**RE: Guardian Storage
Project #1002132**

The purpose of this letter is to explain the modifications that have been made to the Site Development Plan for Building Permit and Site Development Plan for Subdivision Amendment. The project was approved by the Environmental Planning Commission (EPC) on March 10, 2016.

Condition of Approval – 16EPC-40001 – March 10, 2016 – Zone Map Amendment

Conditions of Approval – 16EPC-40002 – March 10, 2016 – Site Development Plan for Building Permit

SHEET 2 OF 6

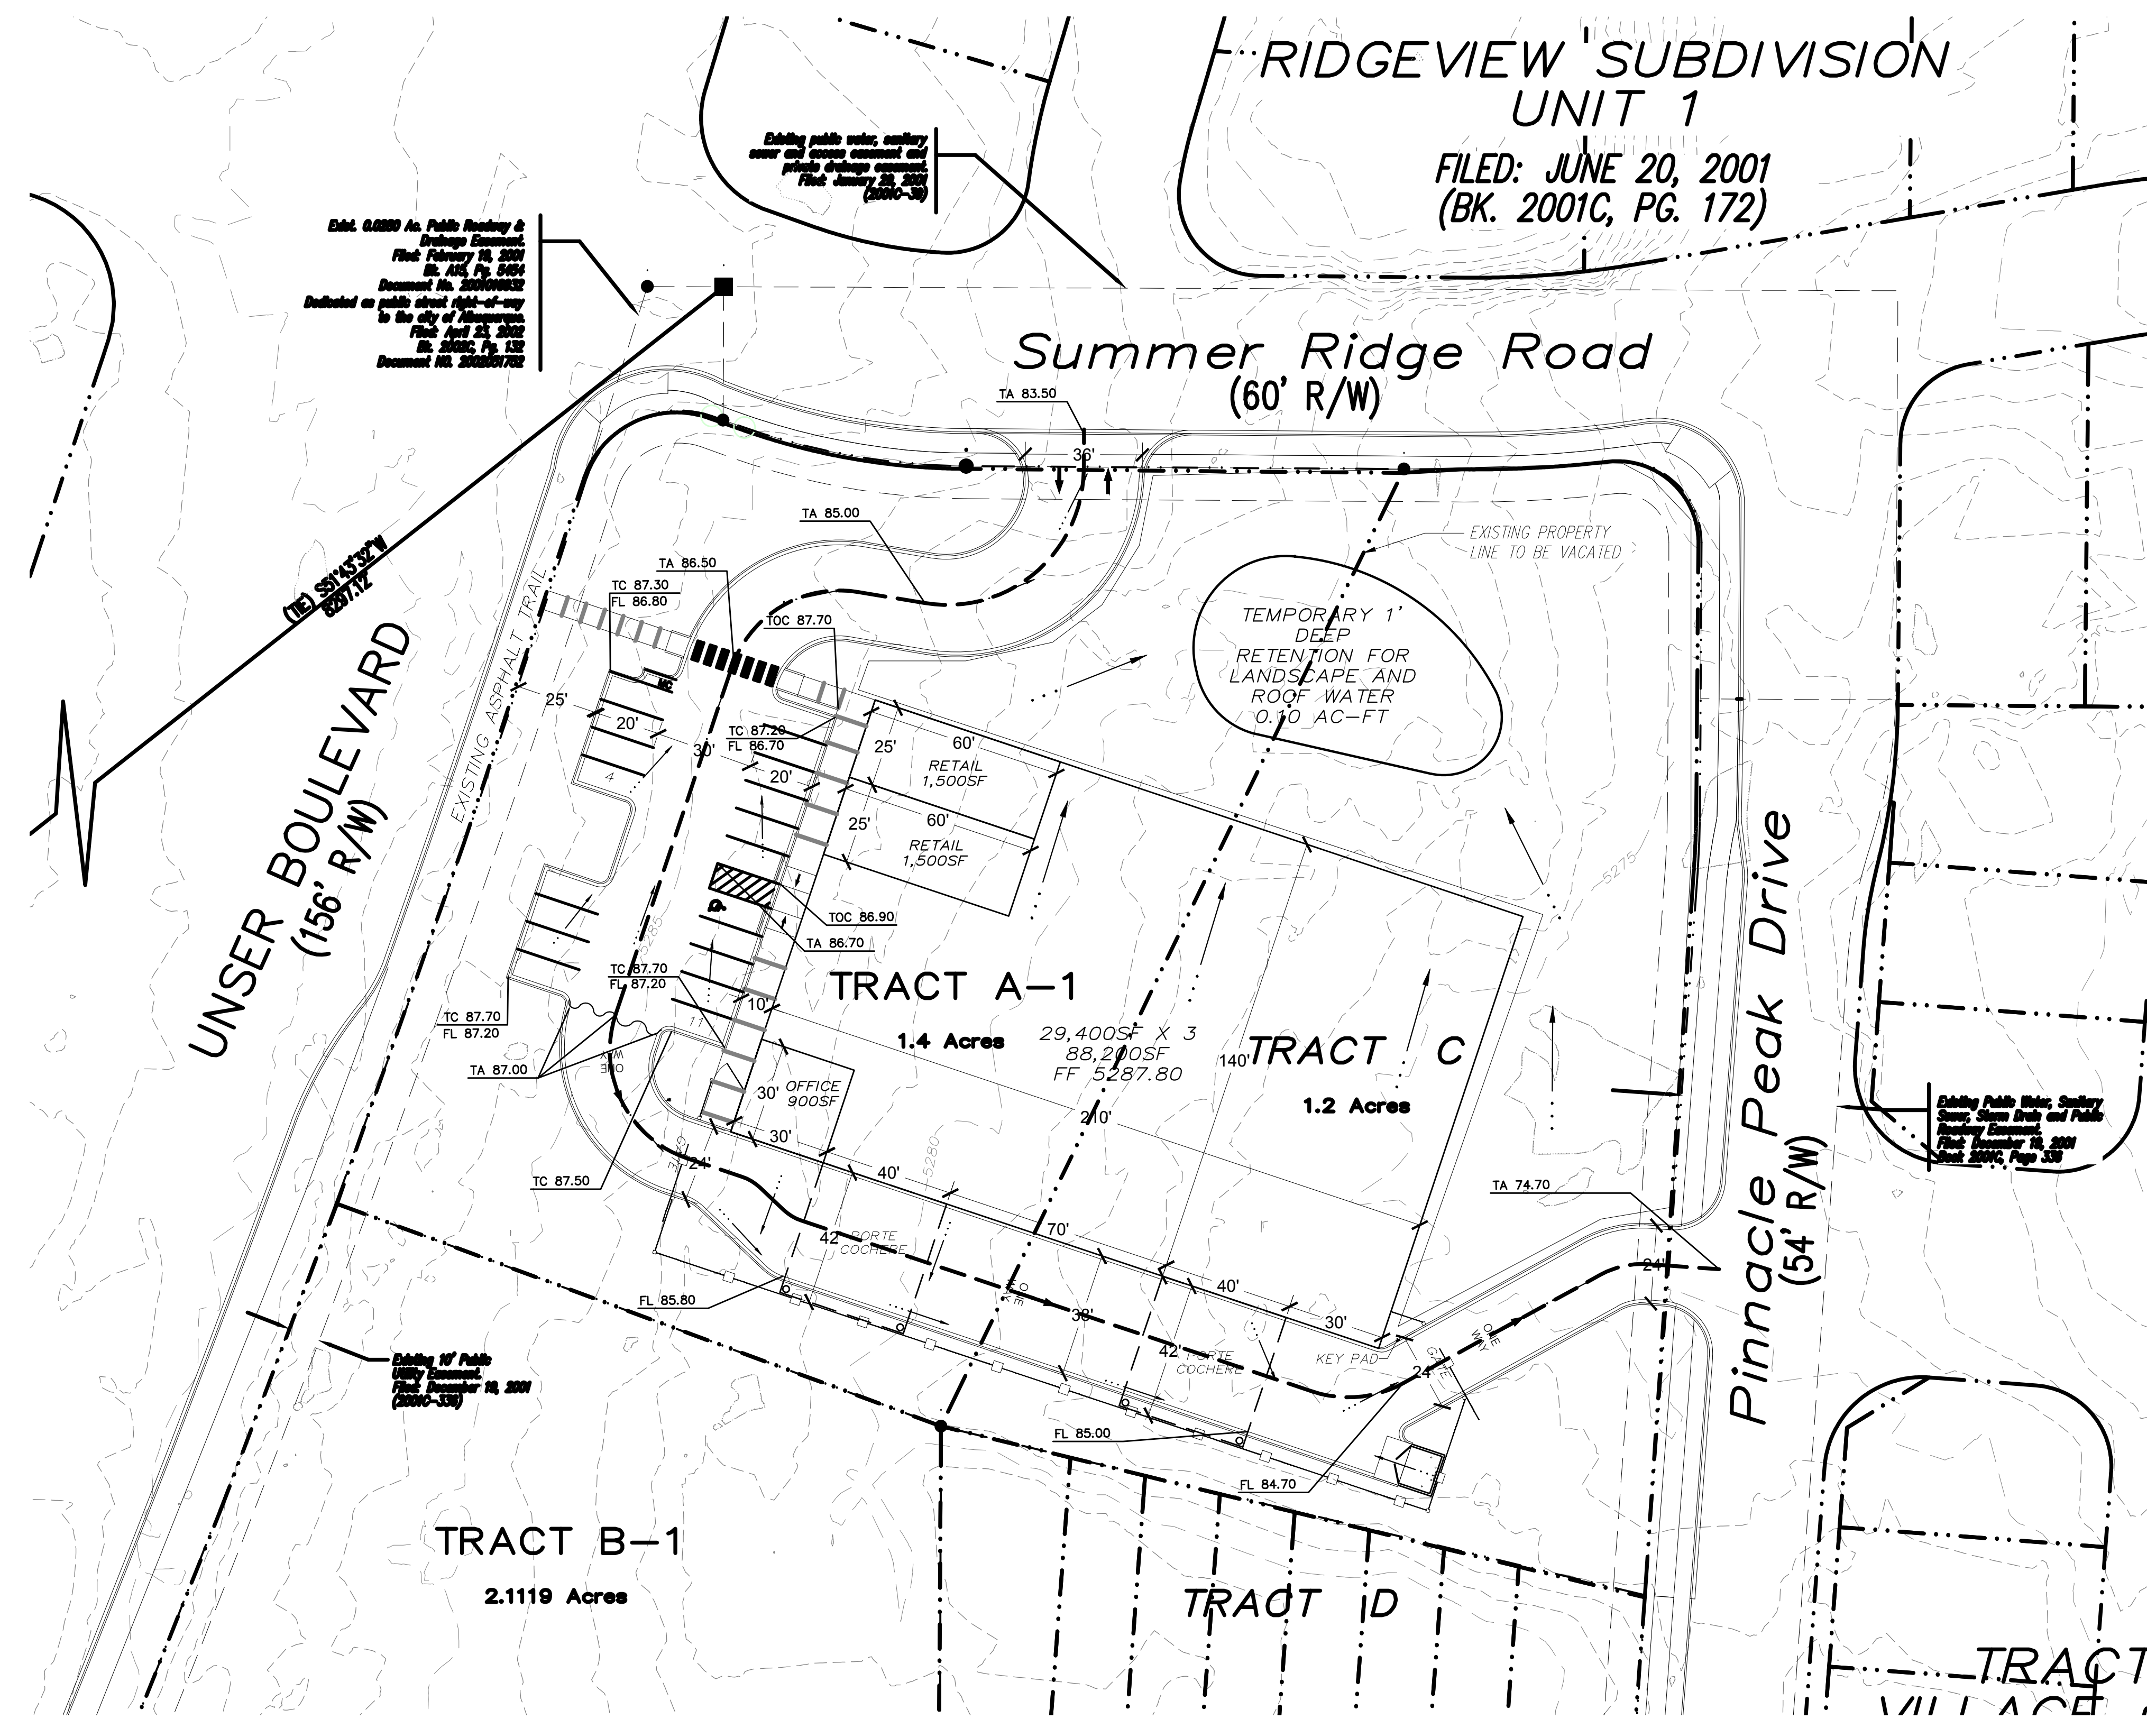
3. The Landscaping Plan on Sheet 2 of 6 shall be revised to include site amenities such as benches and chairs within the proposed landscape and street tree area along Pinnacle Peak Dr. and Summer Ridge Rd. in order to meet the design parameters of the Unser / McMahon Village Center North Site Development Plan for Subdivision.

The Landscaping Plan has been updated accordingly to include benches along Pinnacle Peak Dr. and Summer Ridge Rd.

A. An existing overhead distribution line is located along the western boundary of the subject property on the east side of Unser Boulevard NW. On Sheet 2 of 6, Guardian Storage Landscape Plan, the proposed tree selections are not a compatible height with the existing overhead electric distribution facility on Unser Boulevard NW. Shorter tree selections at mature height are necessary at

this location. PNM's landscaping preference is for trees and shrubs to be planted outside the PNM easement; however, if within the easement, trees and shrubs should be located to minimize effects on electric facility maintenance and repair. New trees planted near PNM facilities should be no taller than 25 feet in height at maturity to avoid conflicts with existing electric infrastructure.

To respond to this condition, we have relocated the trees further east to help avoid the existing overhead distribution line. We have added a note that states "The street trees along Unser Boulevard have been adjusted to respond to the existing power lines and PNM comments." We are required by the Village Center North Site Plan for Subdivision to have Honey Locust and Urbanite Ash trees, which are 35' and 60' at full maturity, respectively. We are also required to have street trees along Unser Boulevard at a rate of one tree per 25 feet, and these trees must be within 20 feet from the back of the curb. Therefore, we cannot choose shorter tree selections or fully avoid the PNM easement.
